Our Case Number: ACP-324126-26

An
Coimisiún
Pleanála

Date: 25 June 2026

Re: Improvements to Public Realm to Bridge Street and lands to the rear and side of The Grain Store, John's Street, New Ross, County Wexford.
Bridge Street and John's Street, New Ross, County Wexford

Site Drainage Layout

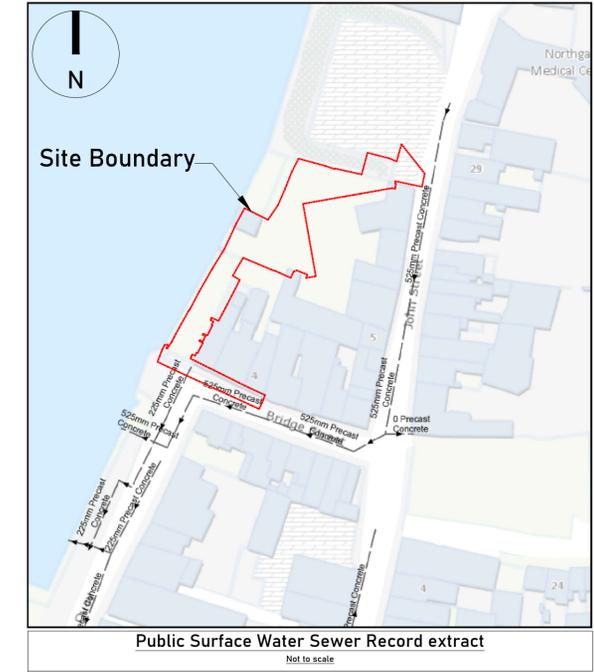
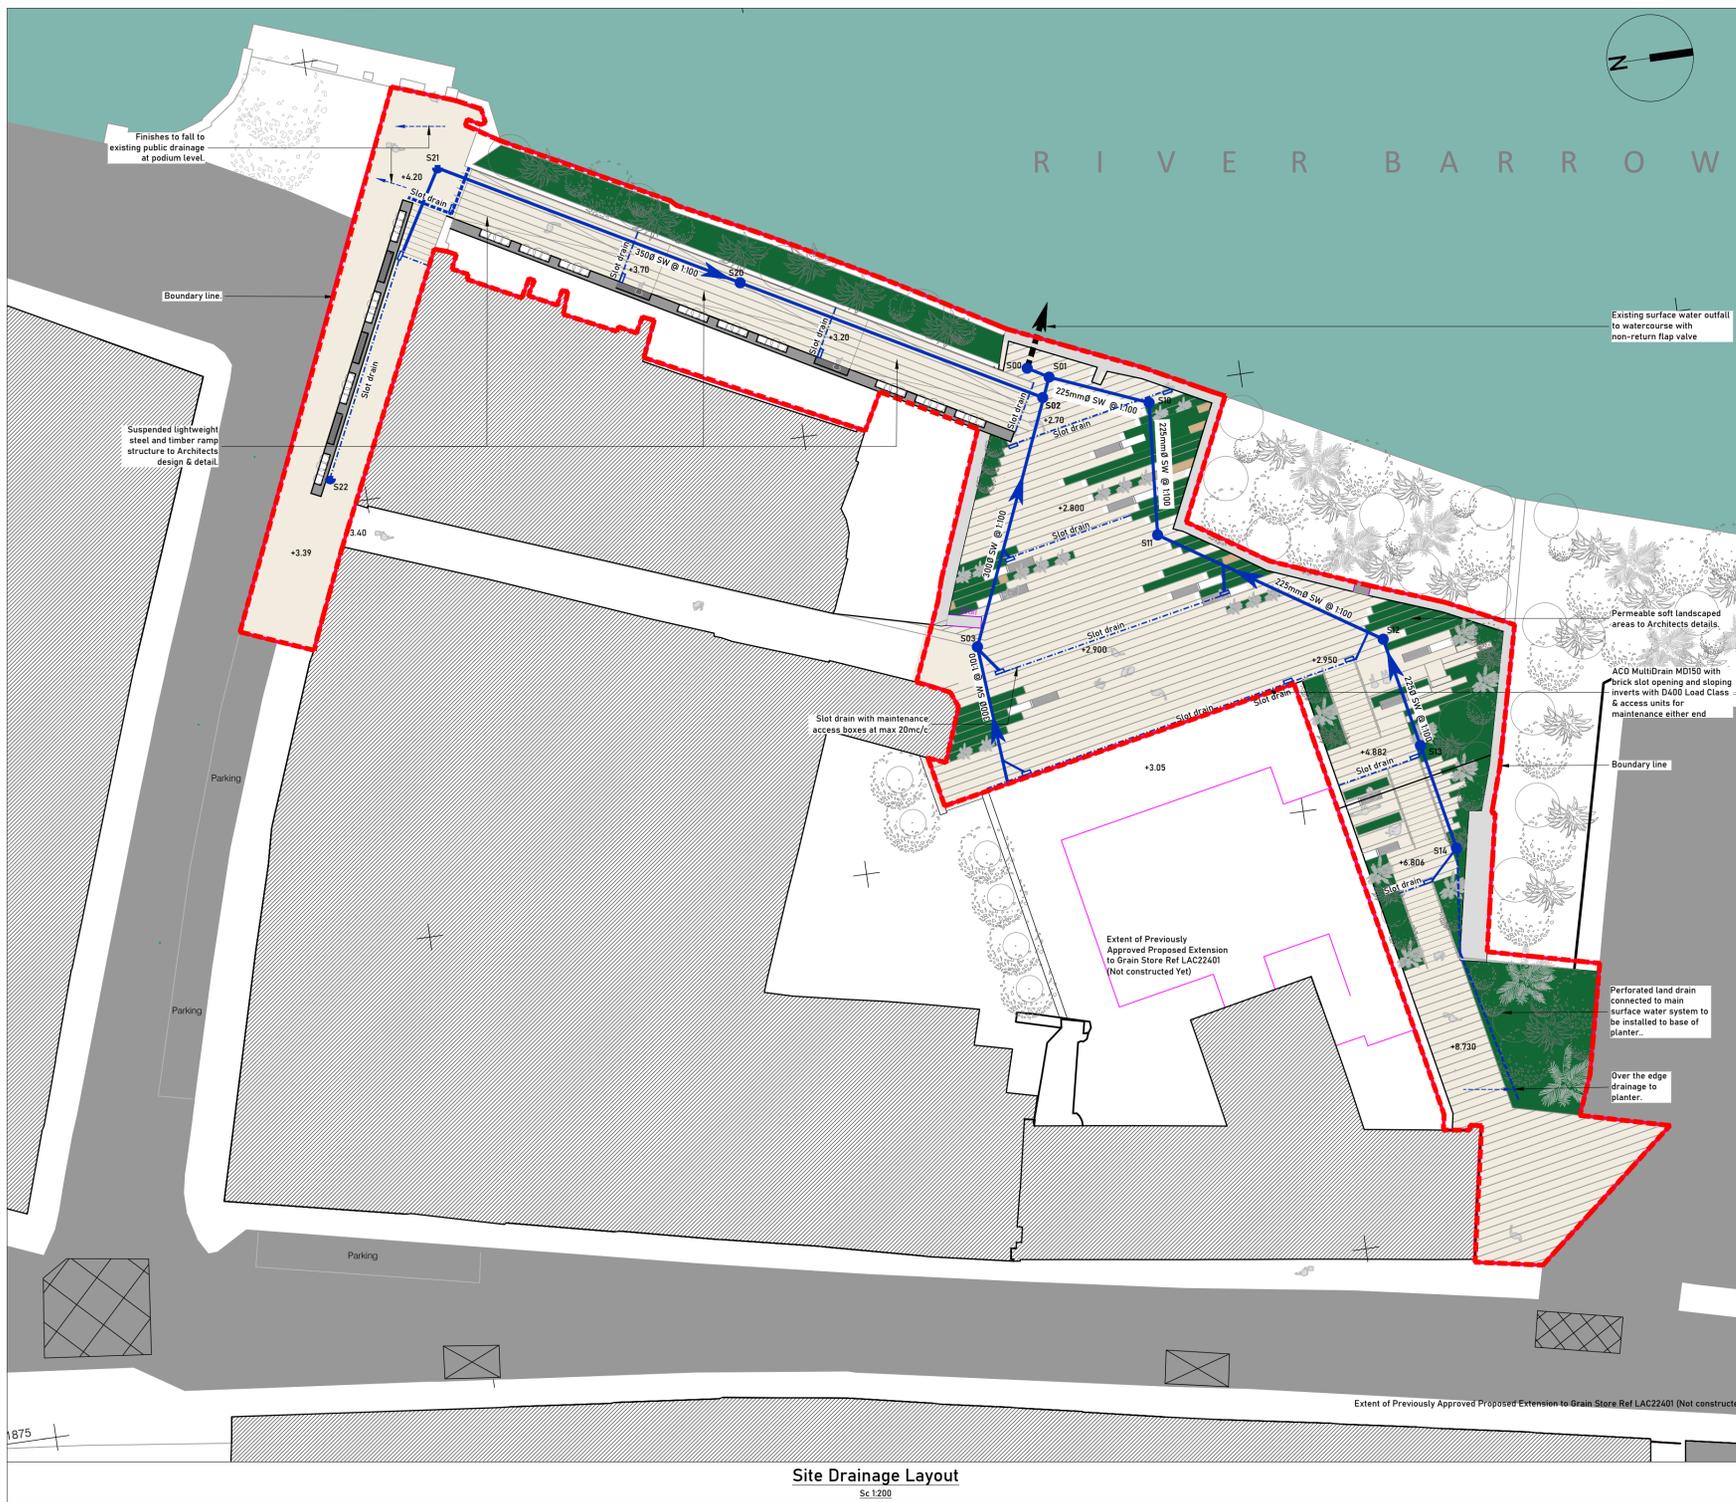
- Both sites would be served by the exact same final section of surface water drainage piping, from where surface water would discharge to the River Barrow. In both applications, the relevant drawing is titled 'Site Drainage Layout'. In the current application, drawing J08-P-10 shows a 300mm diameter surface water pipe running northwards from the site boundary through S03, S02, S01 and S00 before discharging into the River Barrow. The same section of surface water sewer pipe is shown in drawing J08-P-01 for the approved Part 8 development, as the single point of discharge to the adjoining River Barrow and River Nore SAC.

- e. The drainage planning report submitted as part of the application provides calculations of this project in isolation and makes no reference to the approved Part 8 development. While the approved Part 8 development is referenced in the CEMP at section 2.1 and the drainage drawings for the project show that the same surface water outfall point would also serve the approved Part 8 development, no cumulative calculation have been carried out to demonstrate that the level of

surface water from the combined developments would be less than that produced from the entire site at present. Please confirm, by way of an amended drainage report that the proposed drainage network would have sufficient capacity to cater for the proposed development and the approved Part 8 development and also detail on a map the overall catchment of the proposed drainage network including third party lands.

- f. Are there any existing hydrocarbon interceptors on the surface water outfall, or is it proposed to install any on the surface water network prior to surface water entering the River Barrow and River Nore transitional waterbody. If not, please set out how the surface water drainage scheme can ensure that the integrity of the adjacent waterbody would be protected, particularly following flood events, that are stated in the Strategic Flood Risk Assessment to be expected extend inland as far as the café that forms part of the approved Part 8 development.
